Solid Ground Engineering

RE: Serenity Trails PA24-001, Technical Review #2

Project: Serenity Trails

PP-01
3 OF 8

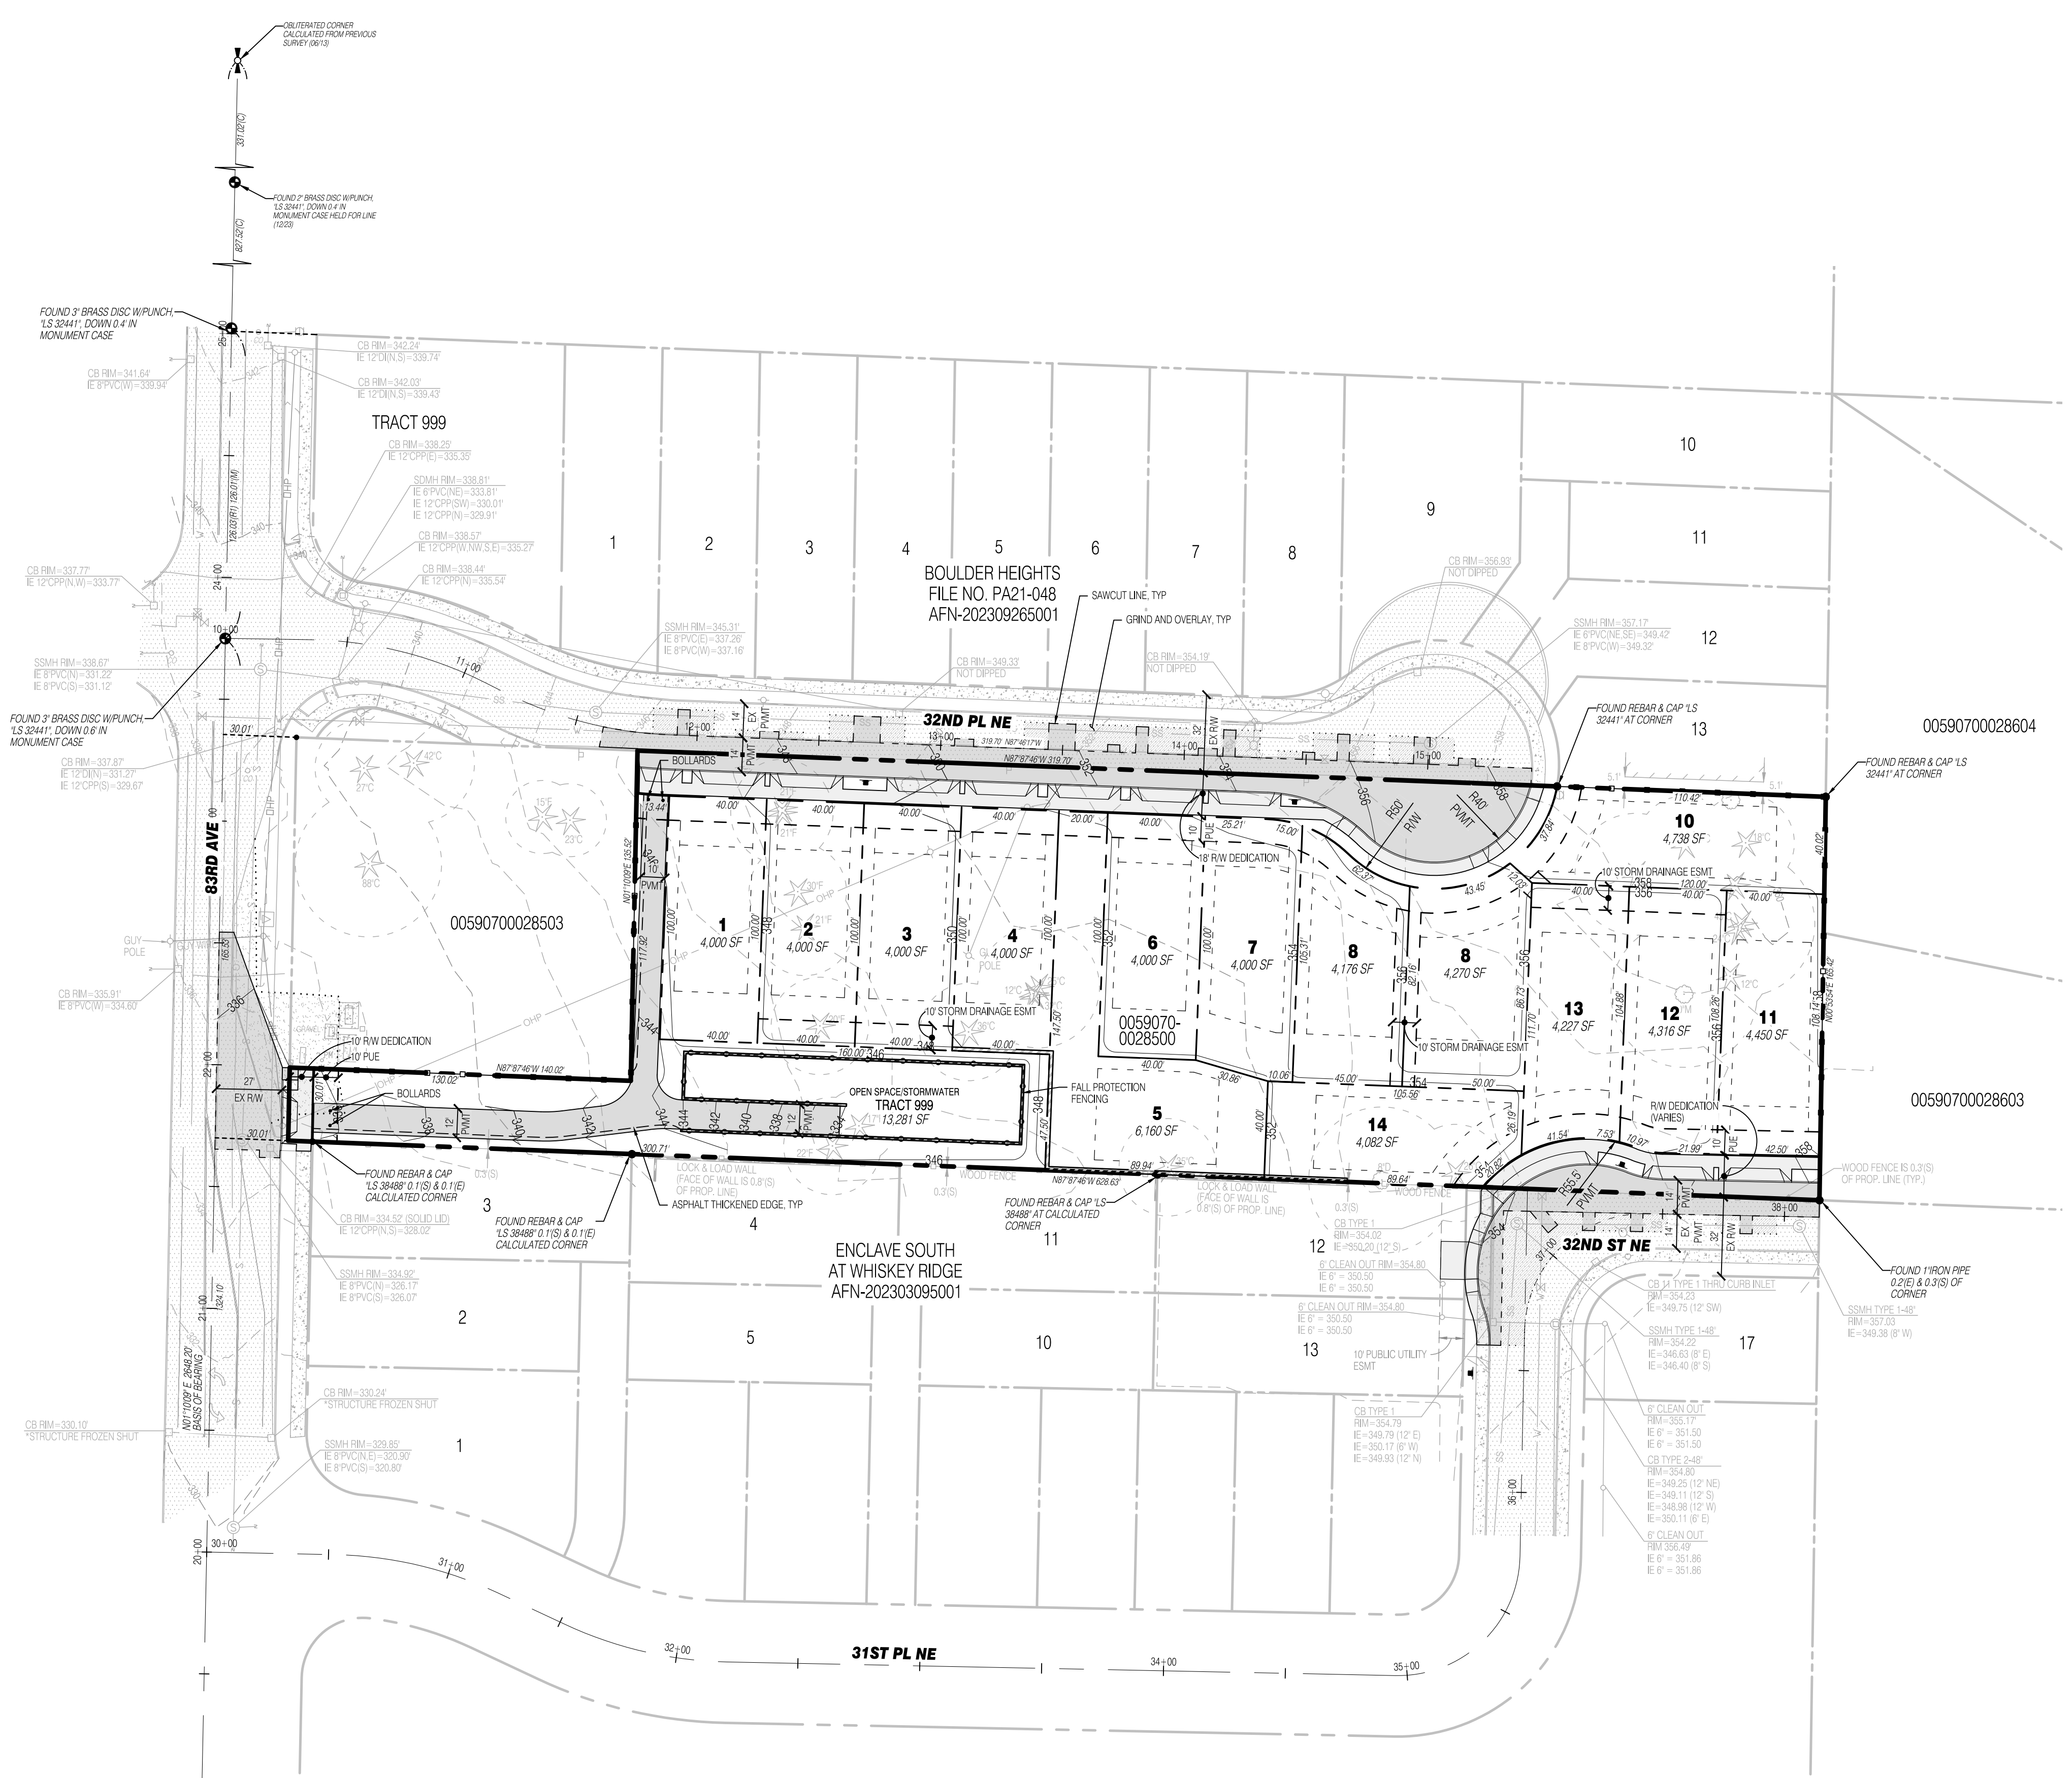
3. Undergrounding of existing overhead utilities along the frontage of 83rd Ave NE shall be required.

Response: A note has been added to sheet PP-01 indicating underground of existing utilities along 83rd Ave NE.
